Rezoning Transportation Analysis

Petition Number: 2020-141

General Location Identifier: Tax ID 12708701

Date	Description
10-26-20	First Review
11-30-20	Second Review (WB)
12-28-20	Third Review (WB)

1. SEE SHEET RZ-200 FOR DEVELOPMENT STANDARDS

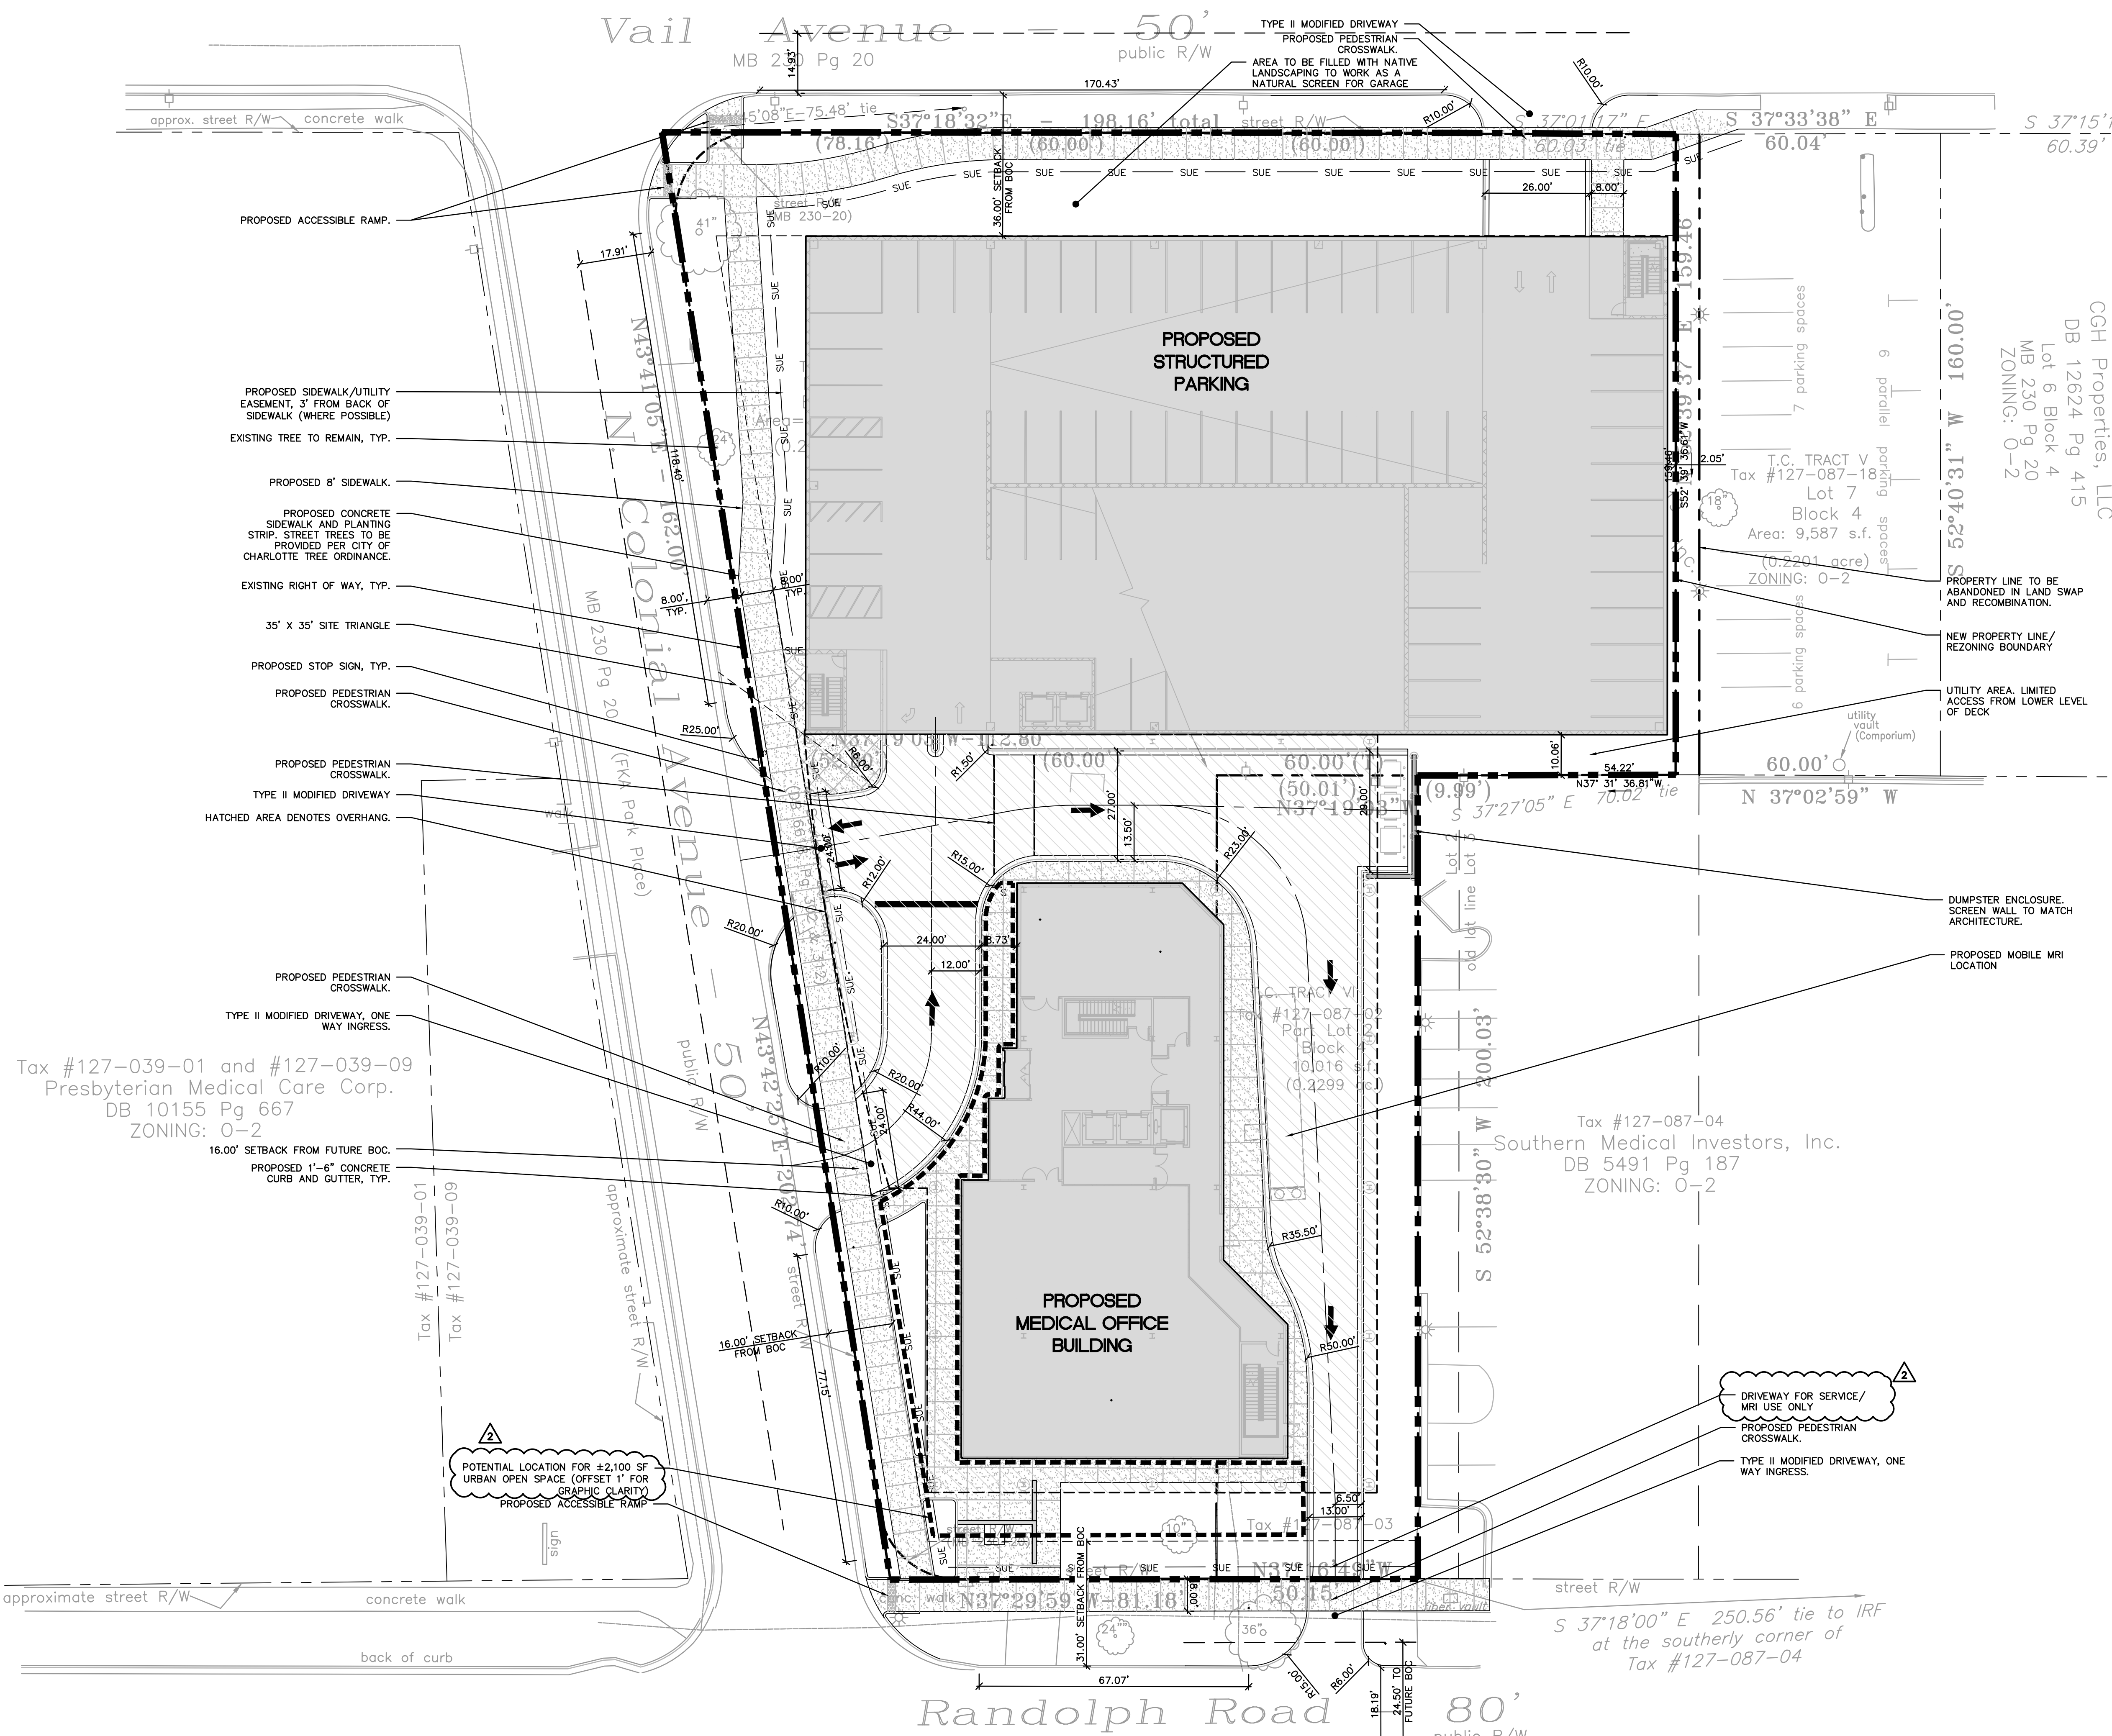
1. ~~**Curblines:** The proposed zoning district has a setback measured from back of the existing or proposed future curblines.~~

~~a. **Randolph Road:** The future location of curb and gutter is in its existing location.~~

~~b. **Vail Avenue:** The future location of curb and gutter is in its existing location.~~

~~c. **Colonial Avenue:** The future location of curb and gutter is in its existing location.~~

Label and dimension curb and gutter from the centerline for each road on the site plan.

3. ~~Revise site plan and conditional note(s) to commit to constructing an 8-foot planting strip, and 8-foot sidewalk along the site's frontage per Chapter 19. The wider sidewalk also meets the Charlotte WALKS Policy.~~

4. ~~Revise site plan and conditional note(s) to commit to constructing two ADA Curb ramps per intersection quadrant in accordance with the ADA law and PROWAG. The site plan shall label and dimension these items from the back of curb and gutter.~~
